**MERIDEN SCHOOL**

**RESPONSE TO  
SUBMISSIONS**

Director	Sarah Horsfield
Senior Consultant	Anna Wang
Project Code	SSDA 9692
Report Number	Final

CONCEPT DESIGN VERNON STREET

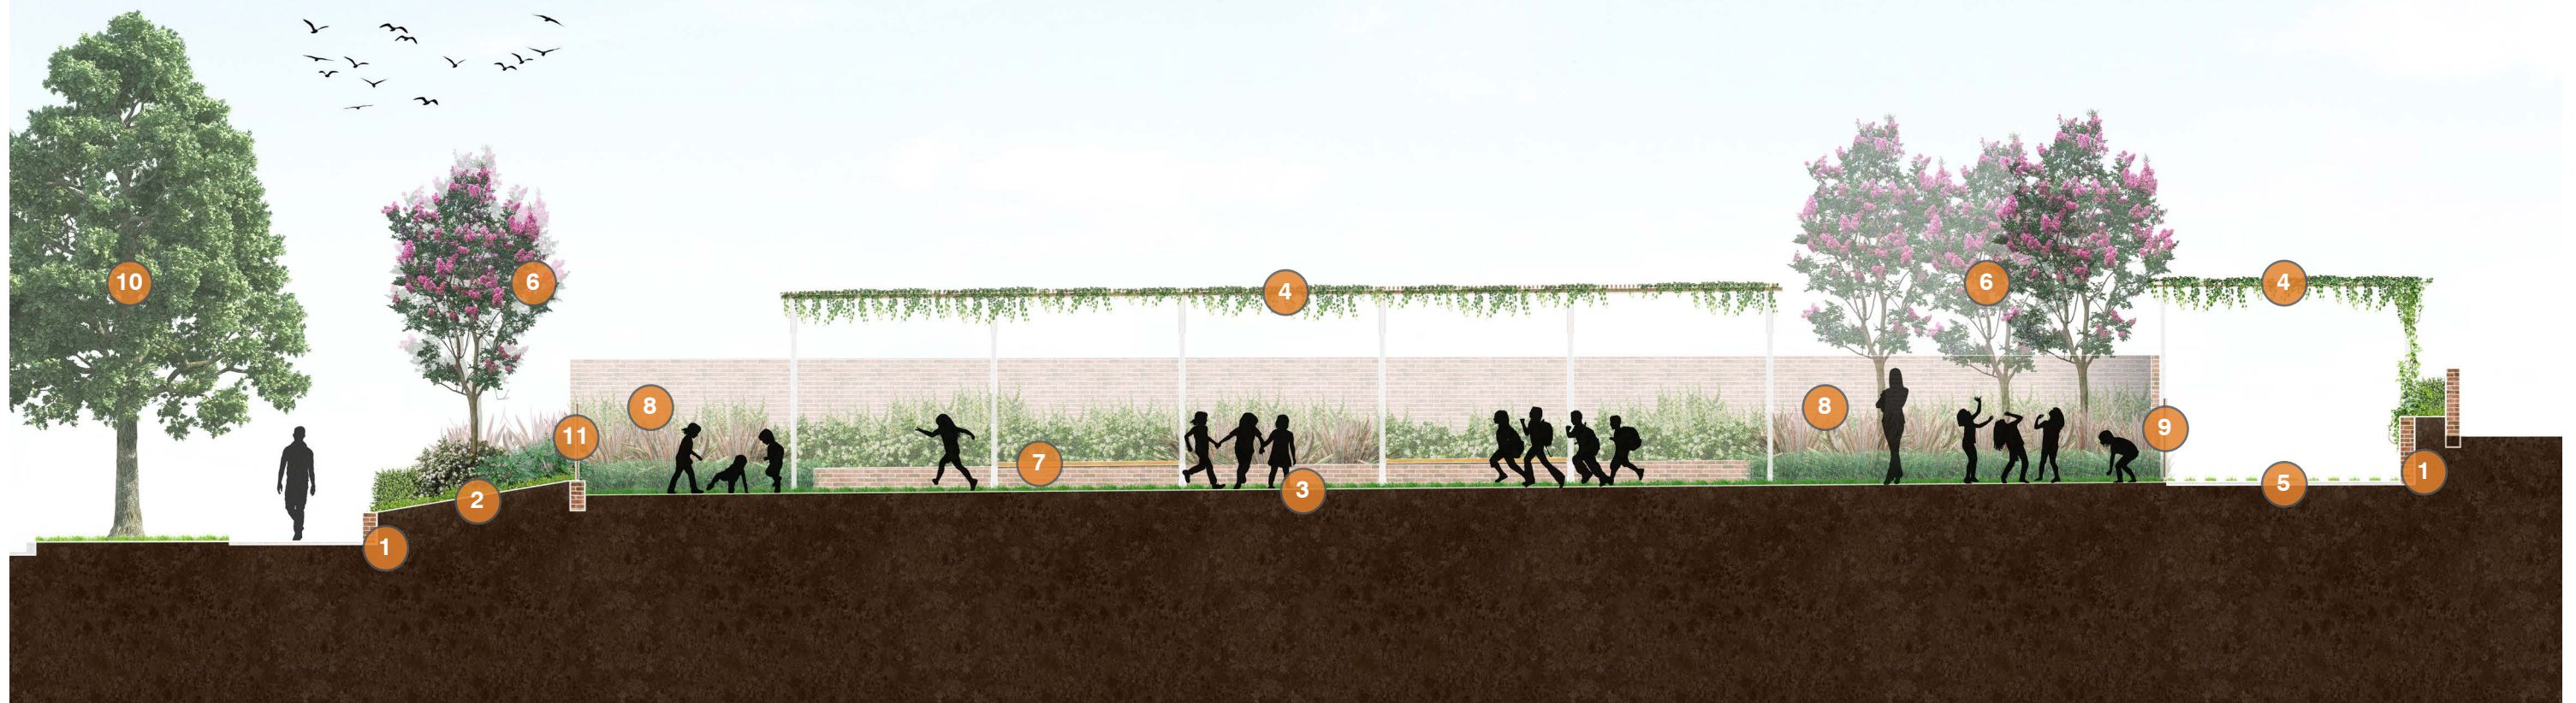
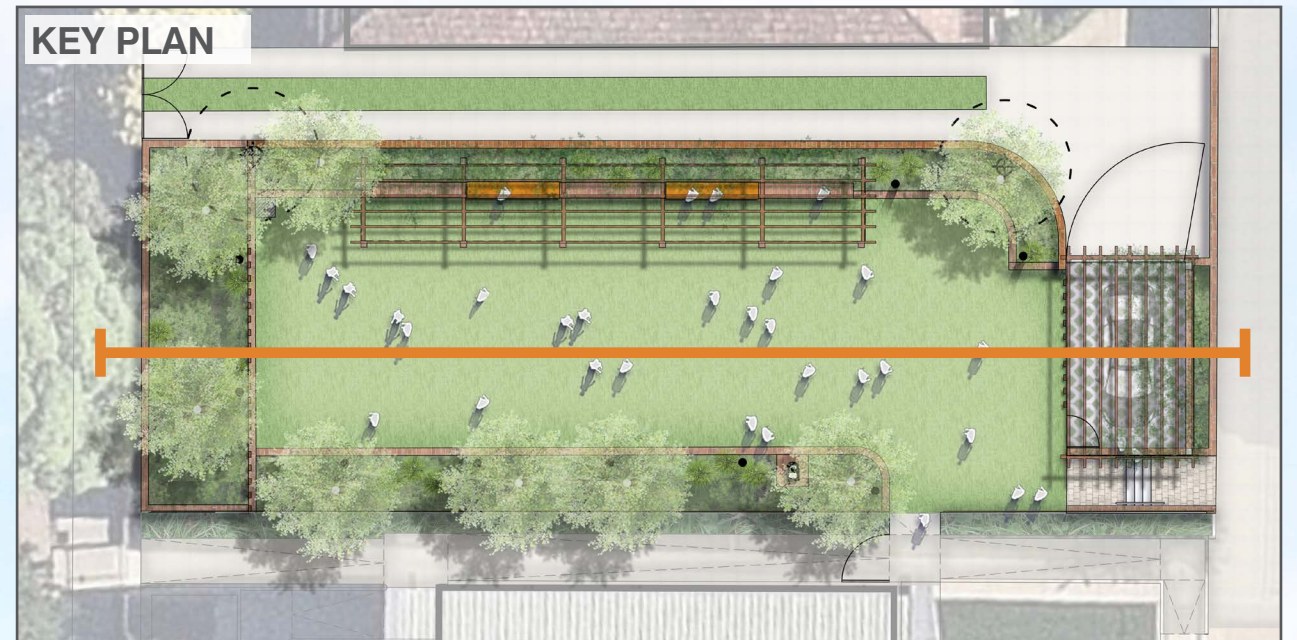
- Traffic and Parking Management Plan; and
- Additional detail on the acoustic wall and associated updated plans.

Submissions received by DPIE and surrounding neighbour requested further clarification regarding acoustic measures and the design of the acoustic wall proposed to be installed along the boundary of the proposed playground area within the Junior School Campus.

As a result of noise modelling, it has been determined that a 2.1m high noise barrier is required on the northern boundary as shown in Figure 5 and illustrated in the Landscape Plan attached at Appendix D.

The proposed acoustic wall is required to be 2.1 metres from the playground level and should be a continuous fence constructed of any of the following materials:

In addition, the existing 1.8m timber fence between the school property and 2 Vernon Street should be made good so that there are no gaps in the timber construction.

The Updated Landscape plan clearly show a 2.1m continuous acoustic walls to be constructed to Acoustic Consultants specifications. The Updated Landscape Plan also shows that the existing 1.8m timber fence between properties (adjacent to 2 Vernon Street) be made good so that there are no gaps in the timber construction. Accordingly, noise generated by students from within the new playground can be adequately mitigated as recommend in the updated Acoustic Report.

Figure 8: Desired Pedestrian Routes between Campuses

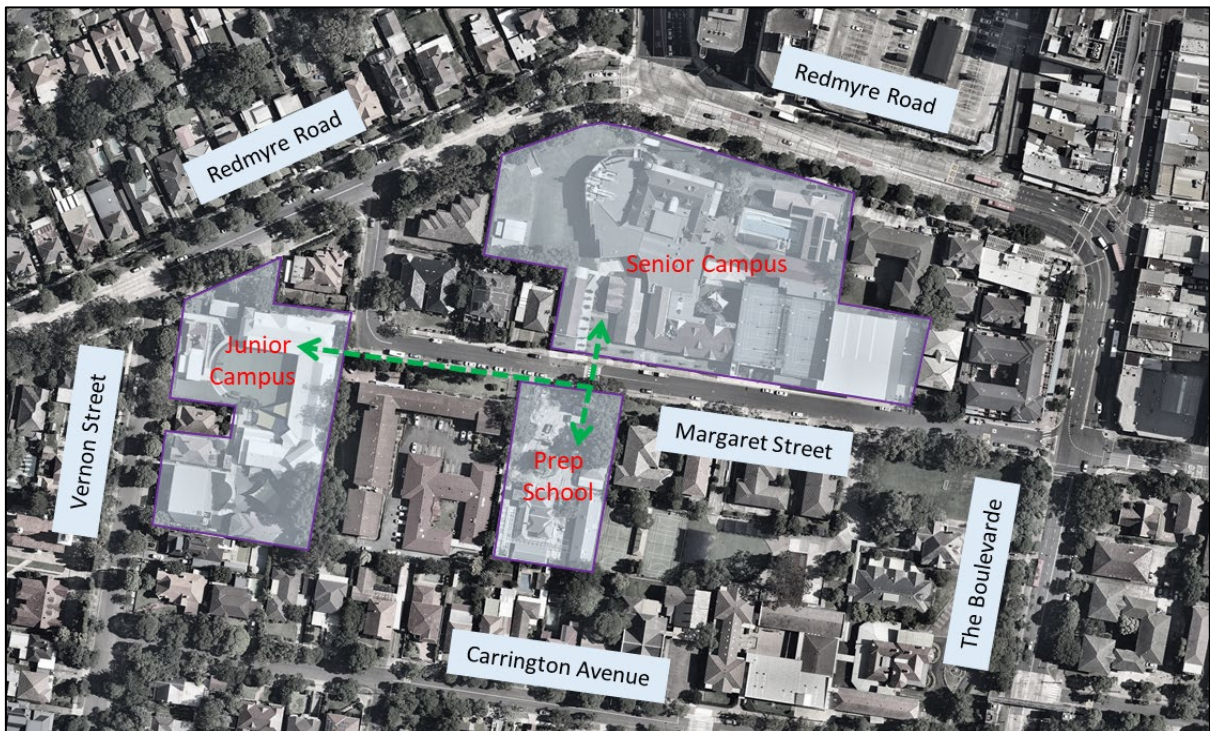
- vehicle pick-up/drop-off management and orderly vehicle queuing;
- maintaining bus accessibility and student waiting areas;
- safe parent and student behaviour during pick-up/drop-off; and
- safe pedestrian movements to the school entrances, minimising vehicle-pedestrian conflicts.

As detailed in the SSDA, the existing pedestrian access points into Meriden School will be retained (refer to Figure 2). There are multiple main pedestrian accesses along Vernon Street for the Junior Campus and along Margaret Street for all three Meriden School campuses.

It is evident from on-site observations that most students, parents and staff walking to and from the school campuses utilise the desired pedestrian routes detailed in Figure 3. It is particularly noteworthy that these routes coincide with the designated pedestrian crossing on Margaret Street.

Figure 13: School Traffic Management Signs and Zones

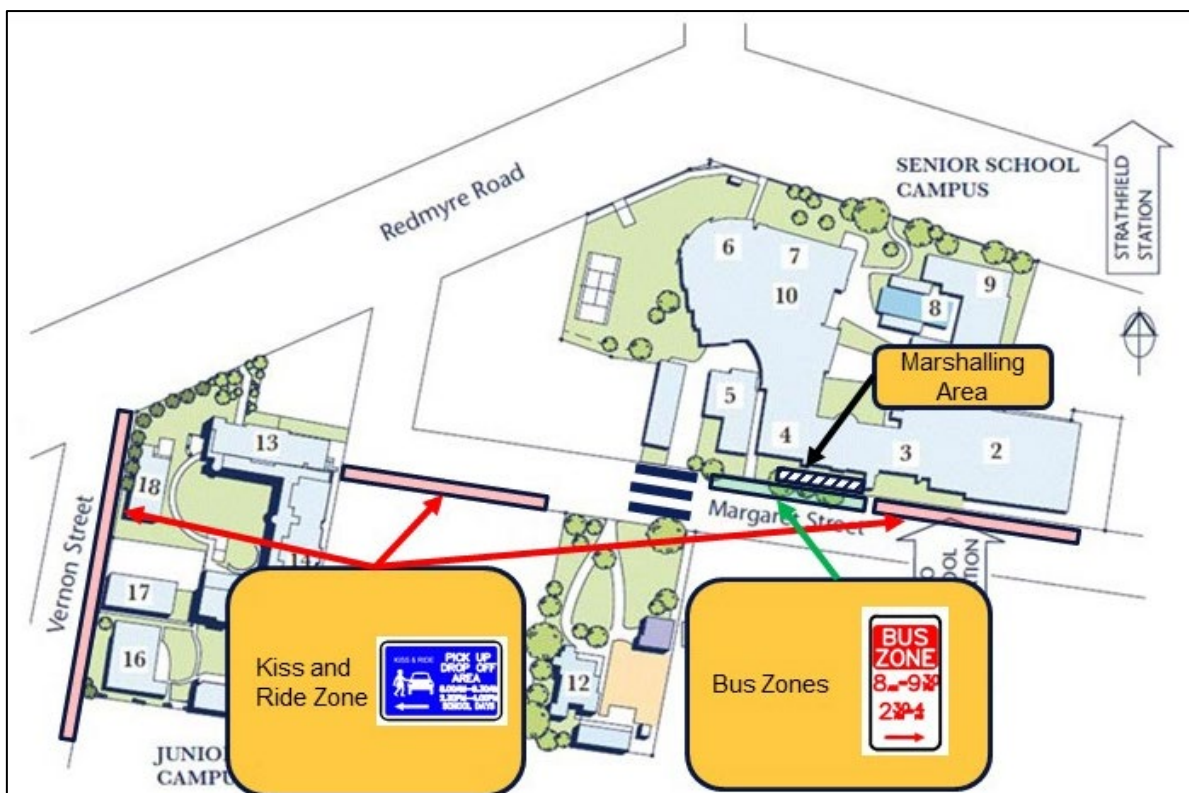
DPIE, RMS and TfNSW requested that a Traffic and Parking Management Plan (TPMP) be provided to support the SSDA which addresses:

School traffic management zone is illustrated below. Figure 1 also demonstrates the pick-up / drop-off zones on Vernon Street and Margaret Street and the bus zone on Margaret Street.

Under the TPMP, PUDO vehicles arriving along Margaret Street, Redmyre Road and Vernon Street are required to queue in an orderly manner that does not obstruct turning movements at intersections. Vehicles arriving are to park within the designated PUDO areas and other vehicles are to queue orderly in the PUDO area. School Supervisors motion the next vehicle to the front PUDO space, when the previous vehicle has departed.

**Figure 5-1 Predicted Operational Noise at 2 Vernon Street –  $L_{Aeq}(15min)$  dBA**

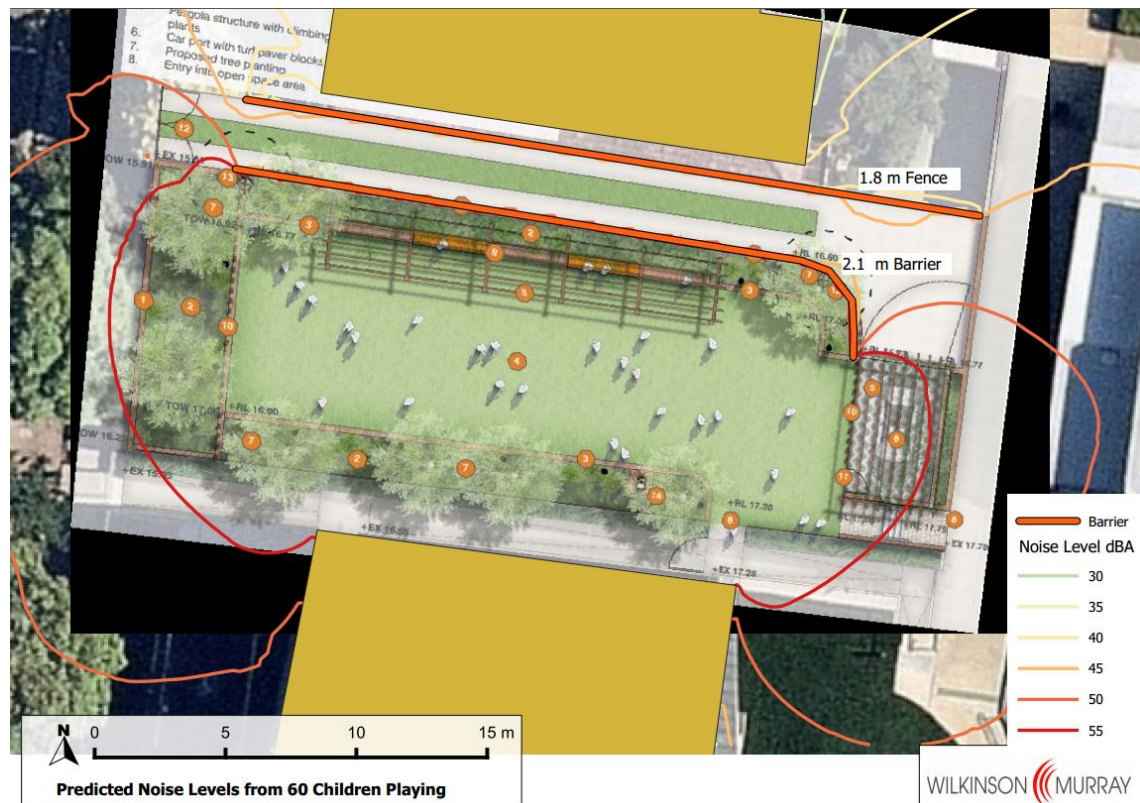
An updated noise assessment of the proposed playground and its potential acoustic impact on 2 Vernon Street is addressed in detail in the updated Construction and Operational Noise Report prepared by Wilkinson Murray attached at Appendix B. The findings of this updated report are summaries below.

Based on the above scenarios, the following LAeq (15 minute) noise levels at 2 Vernon Street are predicted indicating compliance with the following established noise criteria:

- 36 Children in PE class 23 dBA.
- 60 Children at Play 42 dBA.

The noise contours shown in Figure 4 is based on the 60 Children playing scenario, which is the maximum number of children occupying the space within a given time.
